Office of
Environment
& Heritage

Your reference: SSD 6300
Our reference: DOC15/435951-13
Contact: Ziggy Andersons 4927 3151

RE: ENVIRONMENTAL IMPACT STATEMENT FOR THE RIX'S CREEK EXTENSION PROJECT

ATTACHMENT A: OEH REVIEW OF ENVIRONMENTAL IMPACT STATEMENT FOR THE RIX'S CREEK EXTENSION PROJECT (SSD 6300)

Figure 10 Threatened Ecological Communities within the Project Area.

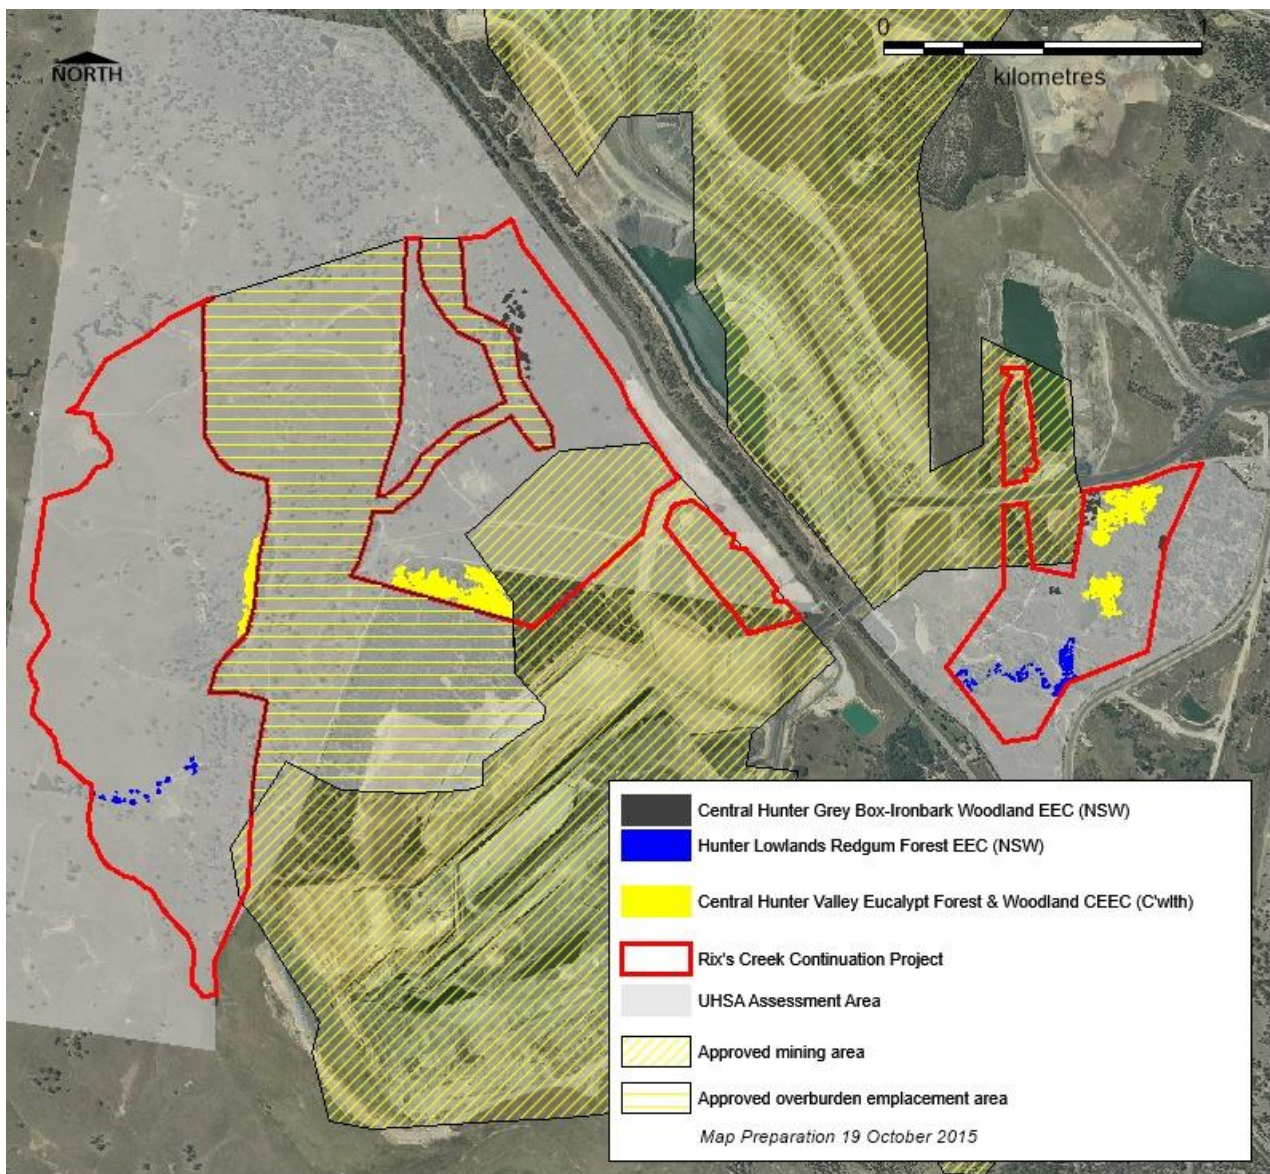
This has been included in the EIS, however, after receiving advice from the Australian Government Department of the Environment, OEH is of the opinion that the areas mapped as the Central Hunter Valley eucalypt forest and woodland is incorrect. The Department of the Environment advice is provided below:

The patches of Central Hunter Valley eucalypt forest and woodland CEEC currently mapped in the EIS are within 30 metres of other smaller patches and therefore should be included with the currently mapped patch, in addition to areas of derived native grasslands within the gaps. OEH requires that updated mapping of the Central Hunter Valley eucalypt forest and woodland and subsequent areas are provided.

Figure 11 Connectivity assessment within a 2000 ha assessment circle, Rix's Creek. Numbers represent total hectares within each unit.

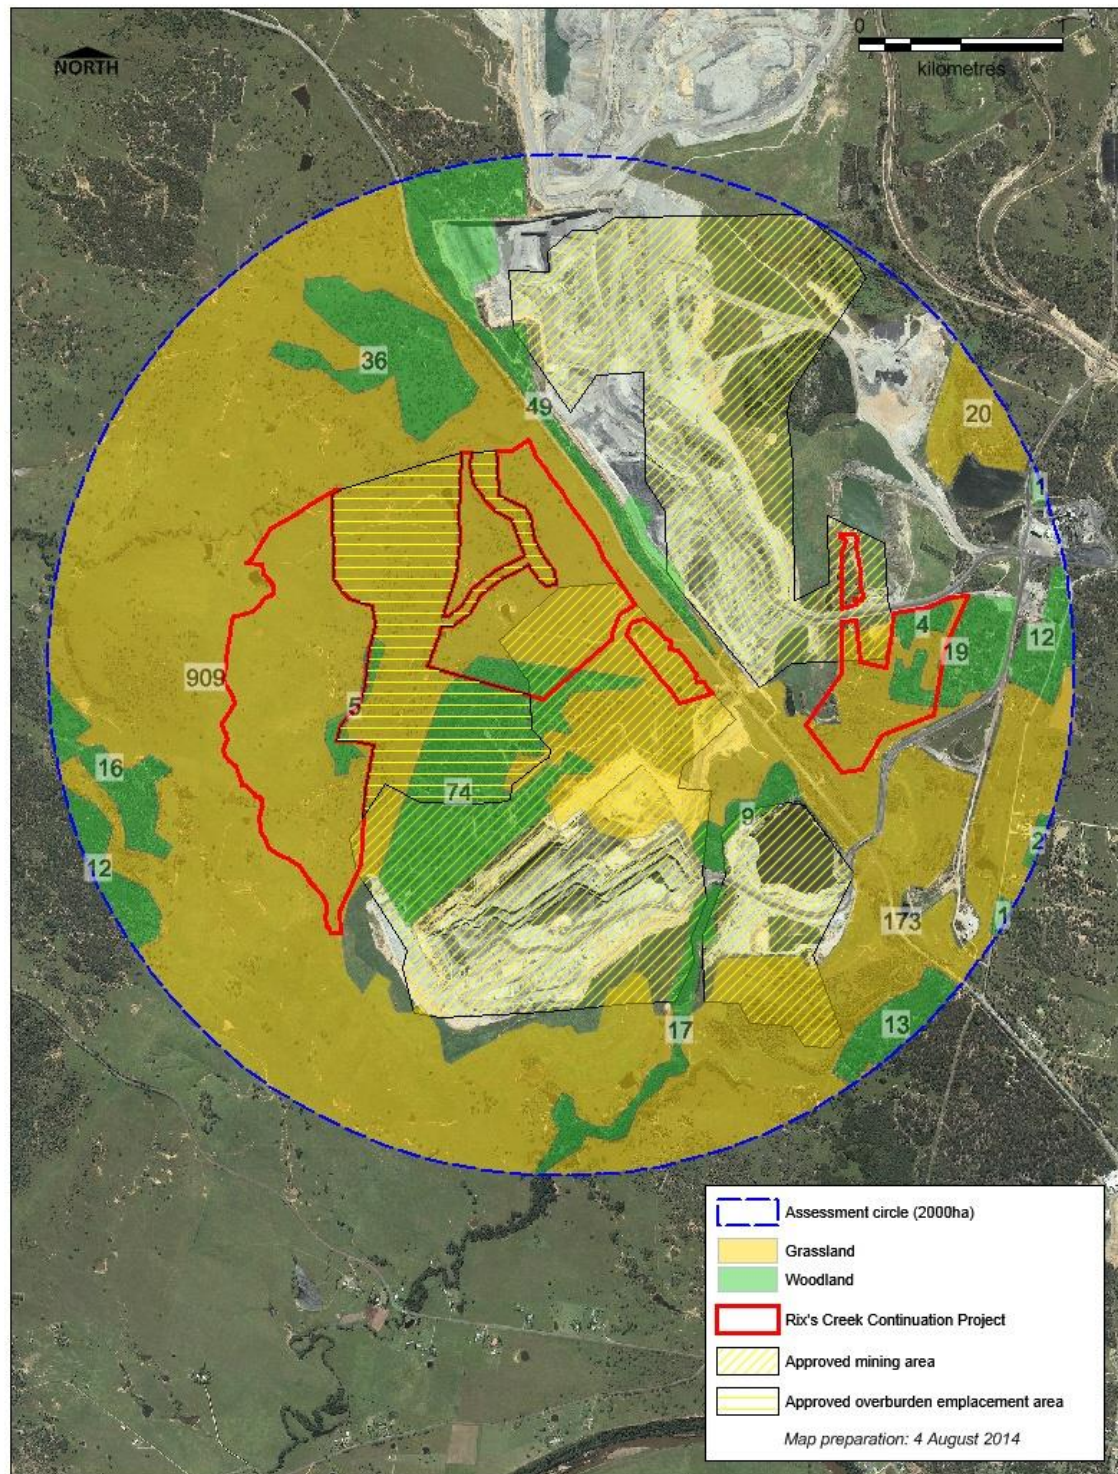
The calculation errors appear to have occurred in the Landscape Value Assessment component. Specifically the '% Native Vegetation Cover' entries do not correspond to the values provided in Table 14 of the EIS. Within the Connectivity Value tab 'Nil Biodiversity links' has been selected, this is incorrect due to the presence of 'Local Biodiversity Links' and based on the information provided within Table 14 the EIS. Under the 'Adjacent Remnant Area' tab, as per the methodology, the maximum value that can be entered is 501 hectares and as such the entry needs to be adjusted accordingly.
